Comment for planning application 23/03428/OUT

Application Number	23/03428/OUT
Location	OS Parcel 7921 South Of Huscote Farm And North West Of County Boundary Daventry Road Banbury
Proposal	Outline planning application for the construction of up to 140,000 sqm of employment floorspace (use class B8) with ancillary offices and facilities and servicing and infrastructure including new site accesses. Internal roads and footpaths, landscaping including earthworks to create development platforms and bunds, drainage features and other associated works including demolition of the existing farmhouse
Case Officer	Chris Wentworth
Organisation Name	Michael Murray (on behalf of CPRE)
Address	22 Thornhill, Chacombe, Banbury, OX17 2JQ
Type of Comment	Objection
Type	neighbour
Comments	<p>CPRE CHERWELL DISTRICT COMMITTEE COMMENTS ON OUTLINE PLANNING APPLICATION 23/03428/OUT - OS PARCEL 7921 SOUTH OF HUSCOTE FARM AND NORTH WEST OF COUNTY BOUNDARY DAVENTRY ROAD BANBURY</p> <p>Introduction</p> <p>This application is essentially the same as the one previously submitted to the CDC in 2023 and which the developers, not wishing to delay adjudication to allow time for the necessary considered scrutiny leg

A361 ROUNDABOUT WITH SECONDARY ACCESS  
(SOURCE DAVID TUCKER ASSOCIATES)

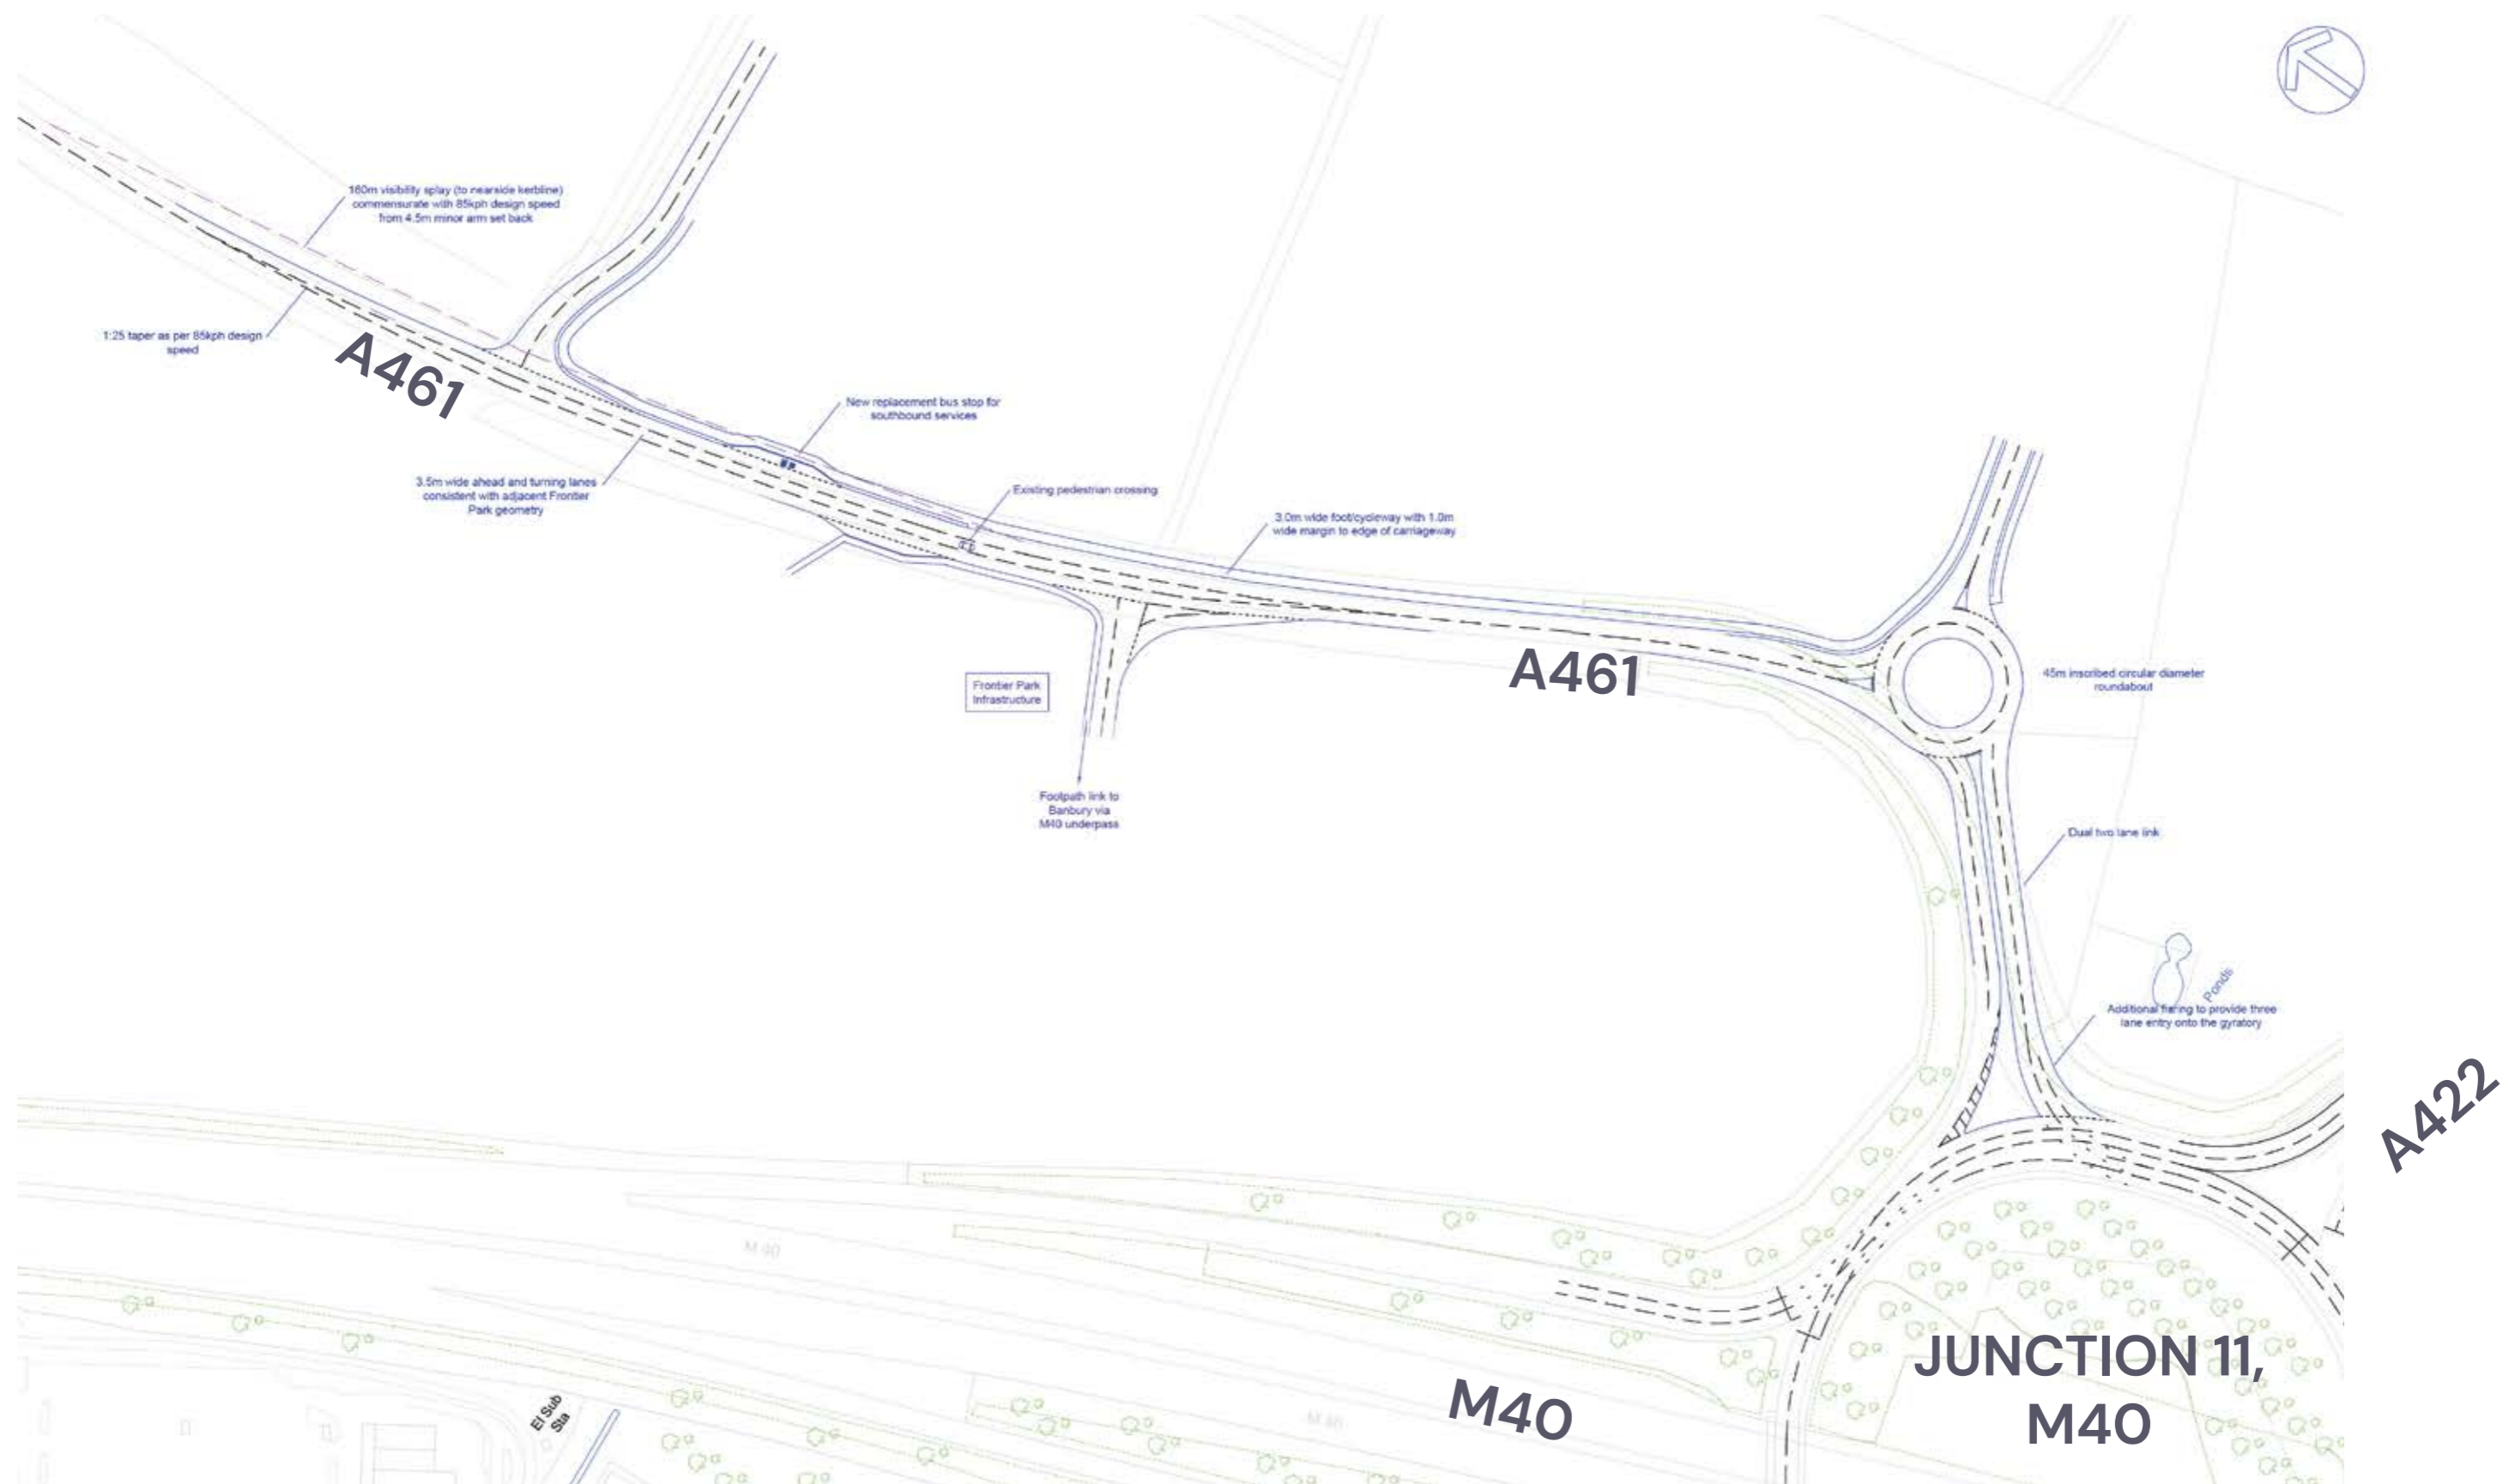
In their consideration of the original proposal, Oxfordshire County Council quite rightly suggested that the proximity of the proposed exit roundabout from the site at a distance of 100m from the J11 M40 interchange poses significant issues in terms of safety and traffic congestion at J11 and surrounding access roads. In conjunction with the extra traffic load anticipated from Frontier Park together with anticipated HS2 traffic, the extra traffic load in the vicinity of the already heavily overloaded J11 would be unsustainable.

1. The major access point to the A361 would be within 100m of the junction itself on a 90 degree curve.
2. Even without the wholly inappropriately sited roundabout there would be three entry and exit points to major warehouse sites within a few hundred yards of the J11 of the M40 with one, at this stage, proposed to be on a tight curve. This can only represent a significant safety hazard let alone the significant potential for traffic build up along that stretch of road. The consultants obviously did not formulate any of their arguments on a day when an incident has occurred within the vicinity of or on Junction 11 of the M40. Even now, relatively minor incidents can have a significant adverse effect on traffic movements in the Banbury area for several miles around J11. Given the proximity of entry/egress to/from the proposed development to J11, it is not unreasonable to anticipate that even an incident within the boundaries of the development could severely impact traffic flow in a wide area in and around Banbury and on the M40 itself.
